TRANSMITTAL SHEET

To:	City of Mercer Island	From:	Erik Voris
Company:	Department Services – Building & Planning	Project:	Project CA023-032
Address:	9611 SE 36 Street Mercer Island, WA 98040	Date:	3/1/2024
		Regarding:	Correction Cycle#1

Critical Area Review 2 Corrections received on 2/21/24 from Molly McGuire

L1.1

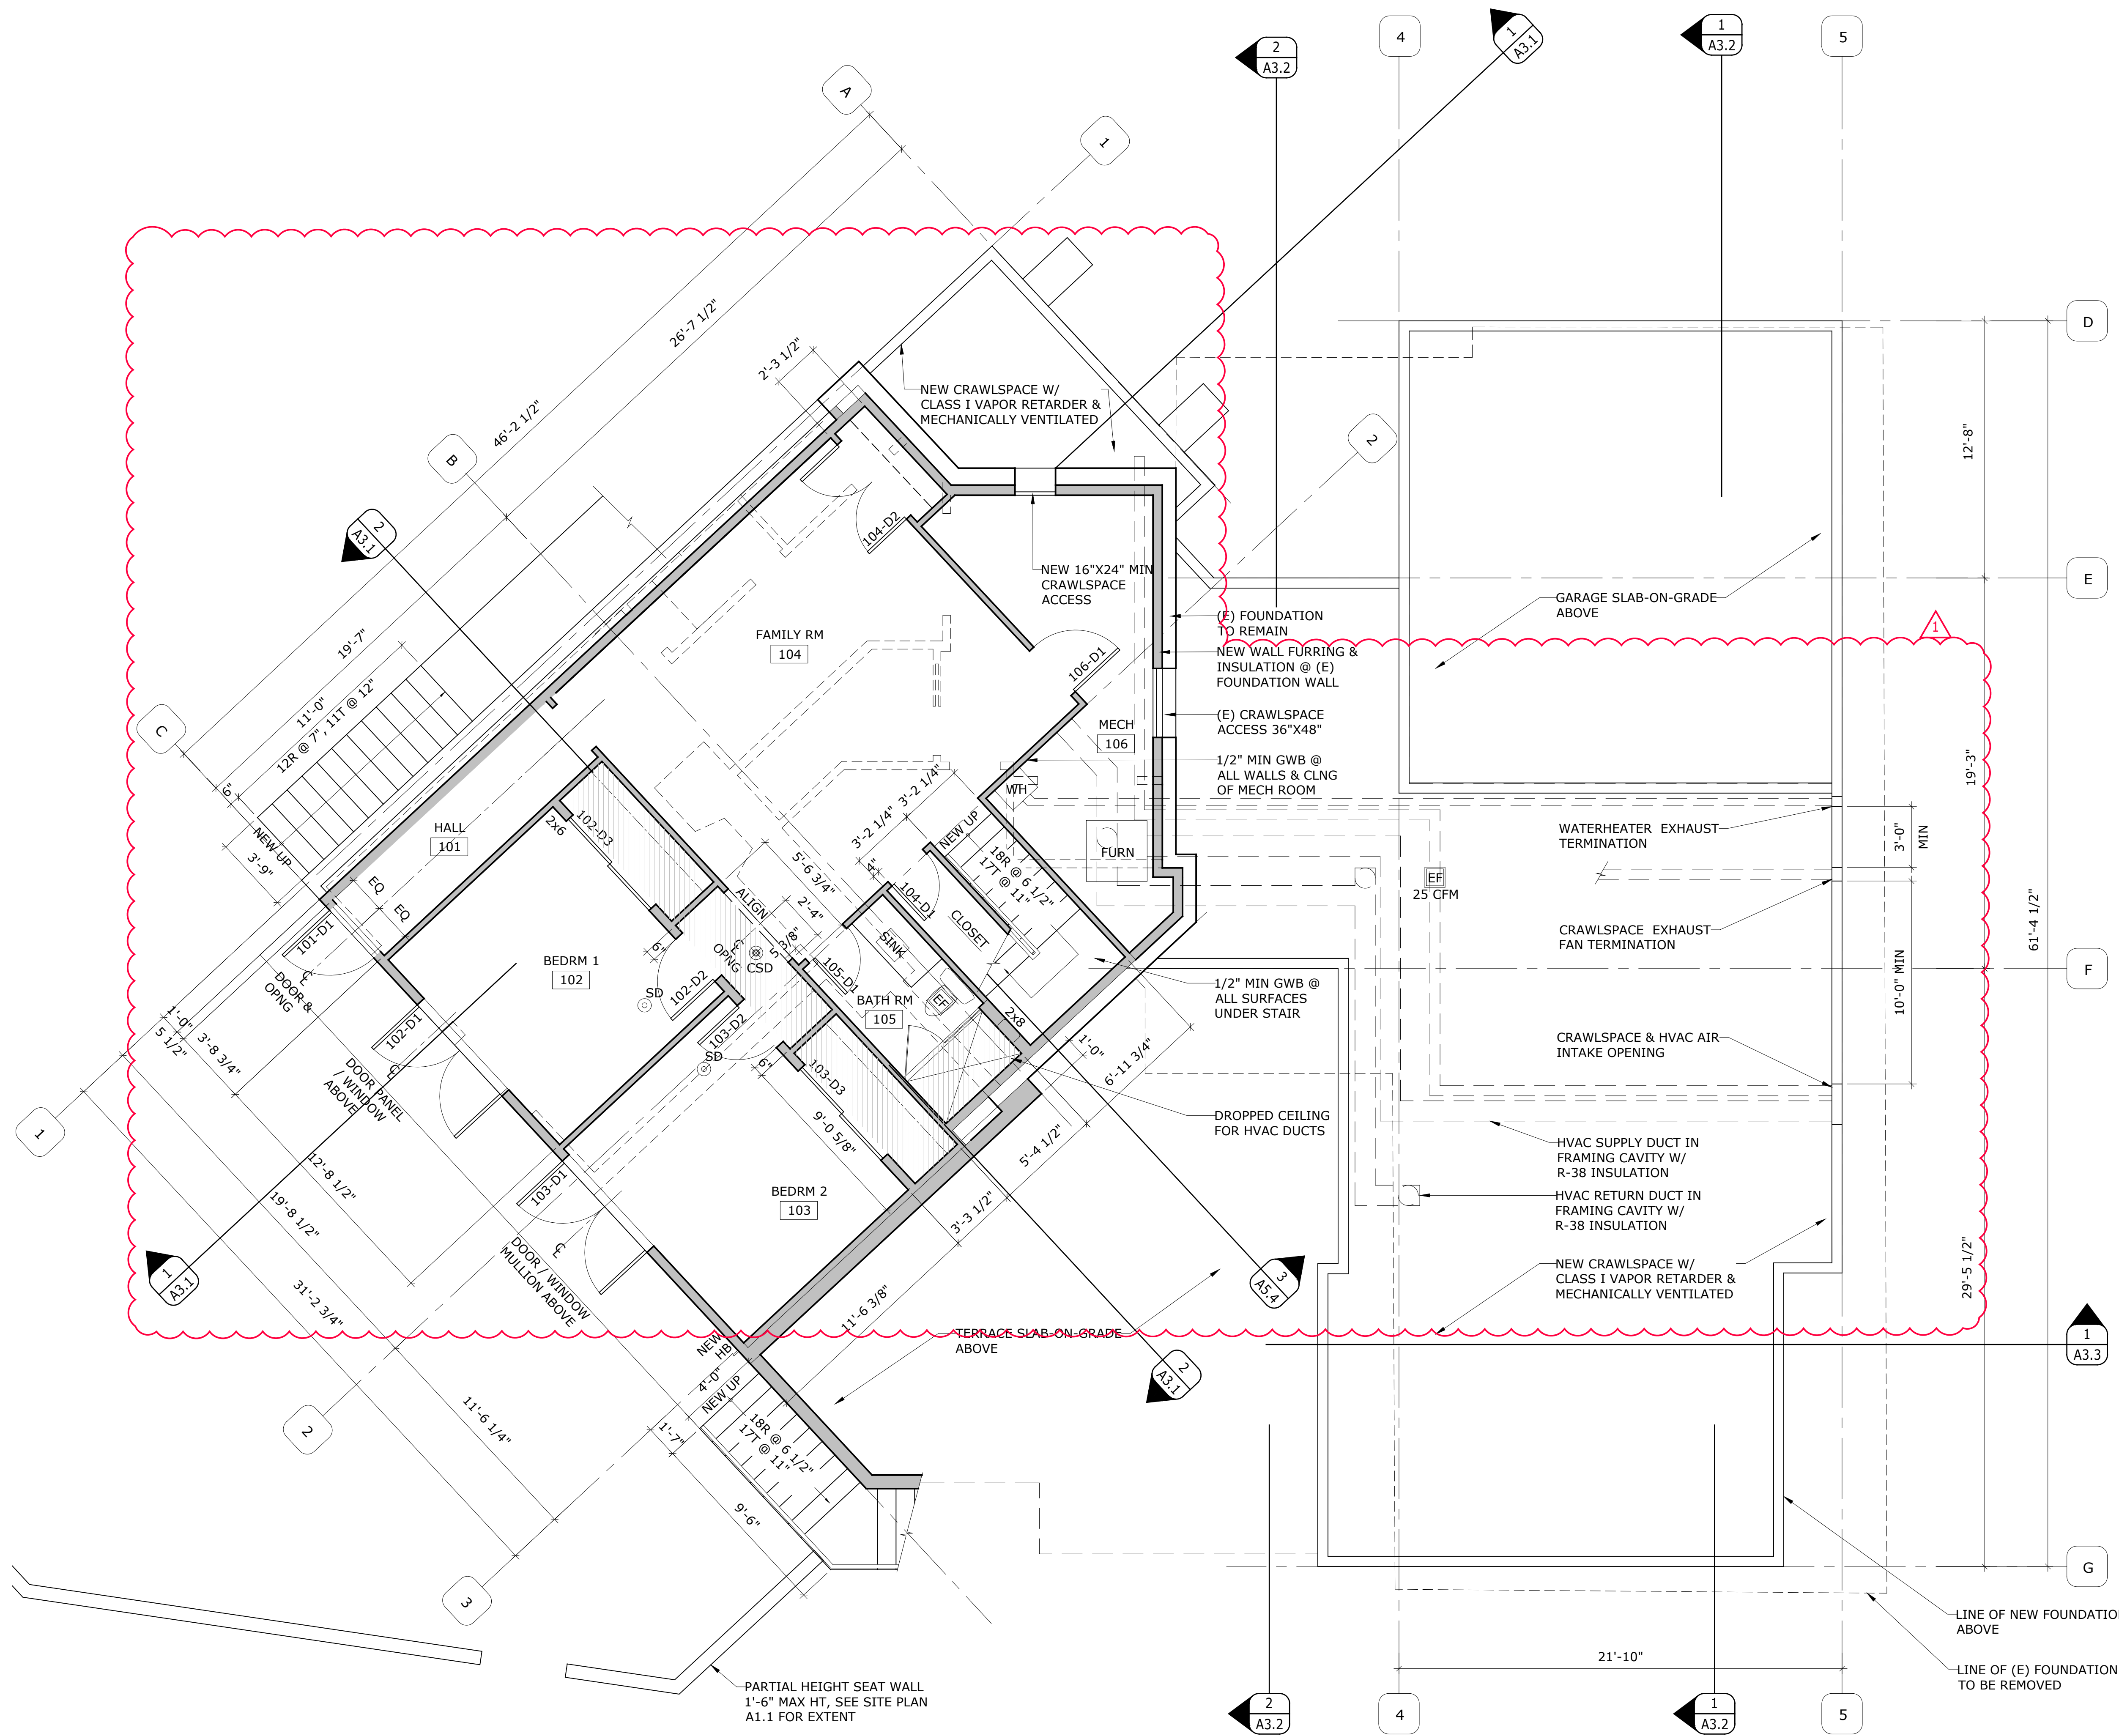
1. The Development Application Forms needs to be signed.
2. Provide a Critical Area Notice on Title consistent with the requirements in MICC 19.07.070. Submit a draft copy to molly.mcquire@mercerisland.gov for review prior to signing, notarizing and recording.
3. The Geotechnical Engineering Study and Critical Area Study prepared by Geotech Consultants, Inc. must include a detailed analysis of mitigation sequencing for the proposed alteration to the geologically hazardous area.
4. A landscaping plan is required for all disturbed areas outside of building footprints and the installation of hardscape per MICC 19.07.160(B)(2)(d).

- 1 - The Development Application has been signed.**
- 2 - The draft of the Critical Area Notice on Title has been sent to Molly McGuire for review.**
- 3 - The Geotech Consultant has provided an addendum to the Critical Area Study to address the mitigation sequencing.**
- 4 - L1.1 Landscape Plan has been added to the Plan Set.**
